**RE: Independence Square
Grading and Drainage Plan
Engineer's Stamp Date 2-27-16 (File: E17D076A)**

Based upon the information provided in your submittal received 12-27-16, the above-referenced plan is approved to obtain a retaining wall permit, at the owners risk, until appropriate private drainage easements are provided for draining this site through the private property to the south. Wall heights may change if there are not appropriate private drainage easements.

The above referenced plan cannot be approved for ESC Permit for building Permit until the following comments are addressed:

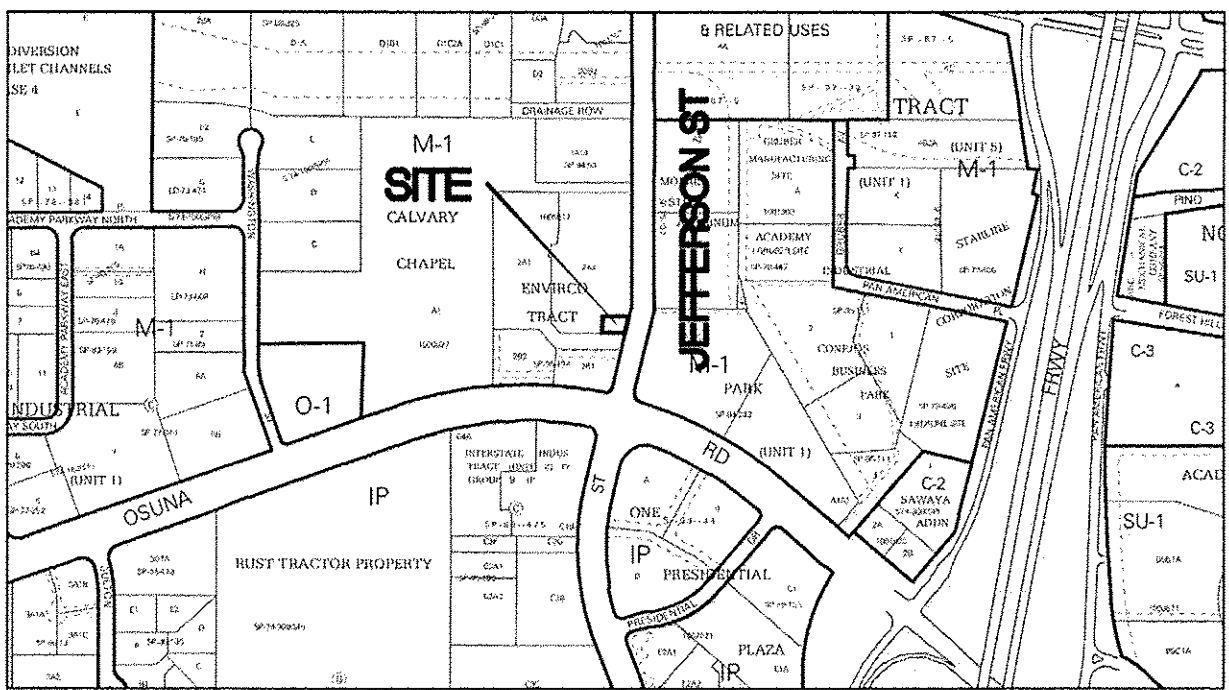
1. Provide appropriate private drainage easements to drain this site through the properties to the south. The drainage report has an arrow for Basin 10 draining south, but nothing for basins 11 and 12 draining through Valero and the referenced drainage plan does not show easements across the sites to the south.

2. Provide additional narrative that discusses the improvements "around" the Starbucks".
3. Proposed spot elevations should be shown for work done on this plan only, unless you wish to certify the grades outside the Starbucks pad in which case it is OK.

4. Provide a build note for the channel through the landscape area.
5. Provide a curb cut at/near the 5138.80 spot elevation to allow water from the drive aisle south of the building to flow into the stormwater quality pond southwest of the building. A channel to the pond bottom would help prevent erosion down the side of the stormwater quality pond.

6. Some curbing along the southerly property line must be removed. Provide permission or modification for the removal of the curbs.
7. Provide details for the trash enclosure to ensure runoff will remain within the enclosure. Included a note that the drain must be connected to a Grease Trap then to the sewer system. Show the location of the Grease Trap and the inverts for the pipe.
